**Application by Aquind Limited for an Order Granting Development Consent for the
Aquind Interconnector (Ref. EN020022)**

**TRANSCRIPT OF SUBMISSIONS TO ISSUE SPECIFIC HEARING 2 Traffic, Highways
and Air Quality
PORTSMOUTH CITY COUNCIL
30 NOVEMBER 2020**

Plate 5 – Typical Schematic of Joint Bay (distances in millimetres)

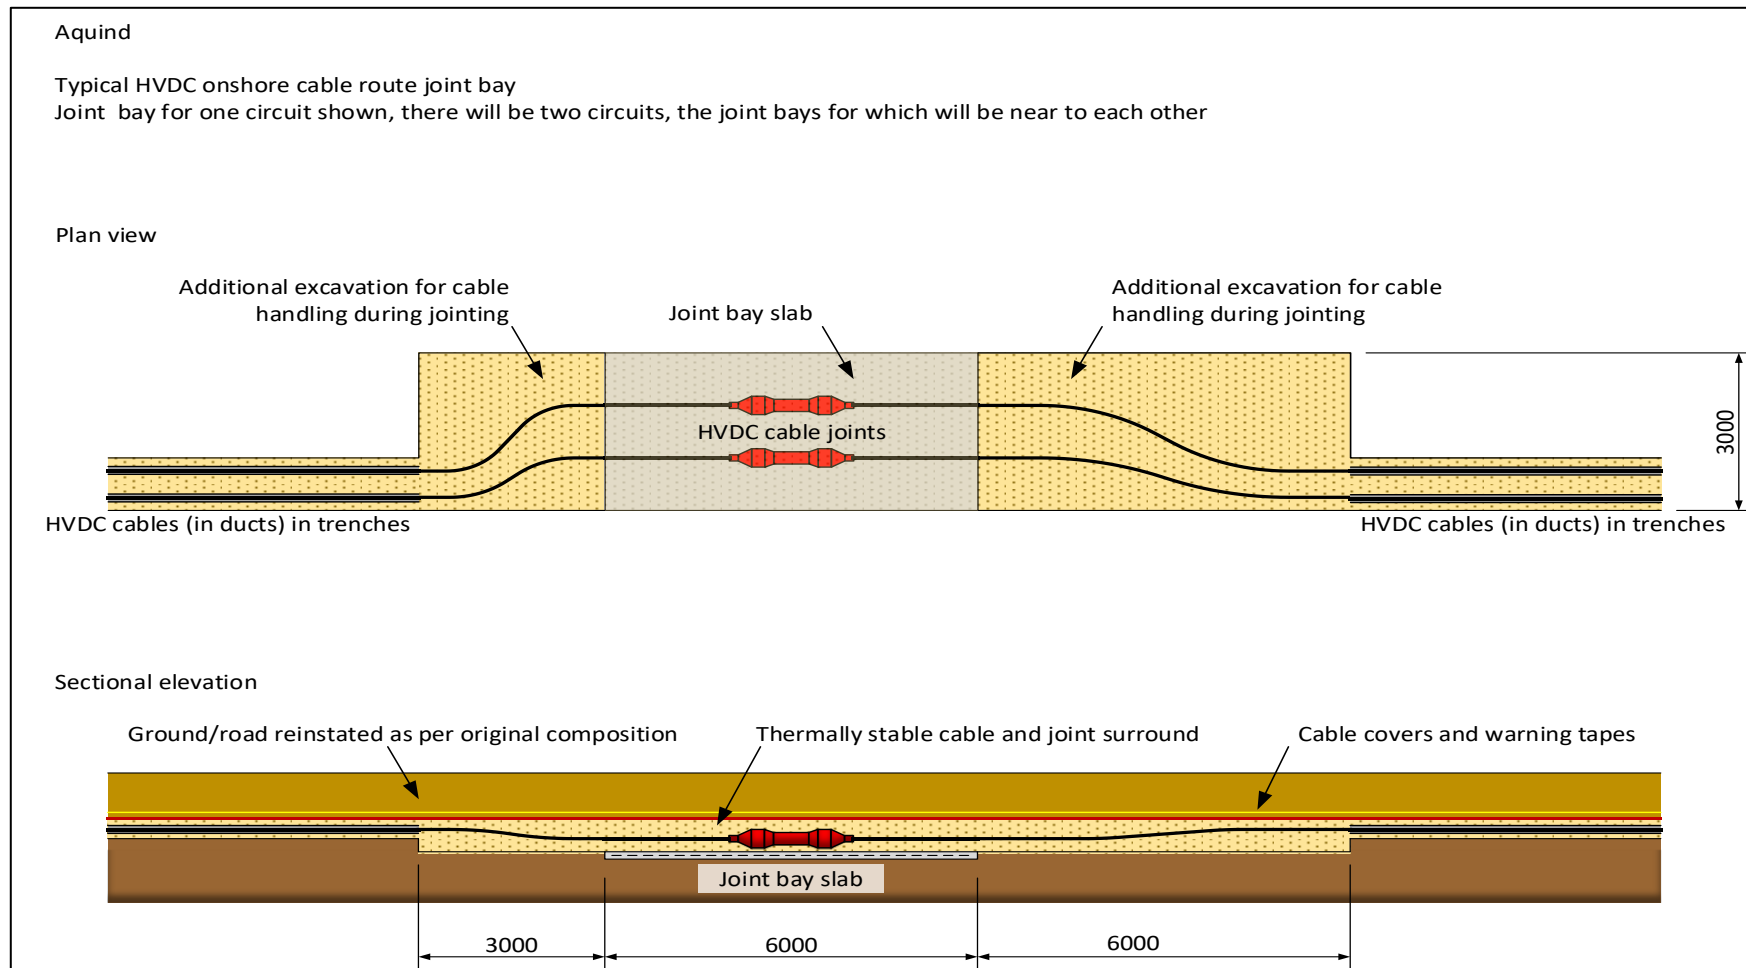
Given the Applicant's response to Local Impact Reports ([REP2-013], page 3-50, 5.5.2) regarding the position of joint bays, and noting that the construction of a joint bay takes 20 days, what confidence can the highway authorities have that the construction of joint bays will not take place within the highway?

- 4.6 In PCC's view and in its capacity as LHA it can have no confidence that the joint bays will not be located within the highway as required, as in the Applicant's response to Local Impact Reports ([REP2-013], page 3-50, 5.5.2) the applicant is specific that 'The location of the joint bays will be off the roads, (e.g. in verges) where practicable' PCC's emphasis). This implies that the joint bays are likely to be in the highway and may well be within the carriageway where it is not practical to position these in verges.
- 4.7 As the applicant has not undertaken full surveys of the locations for joint bays the LHA can have no confidence as to the practicability of locating them outside the carriageways.
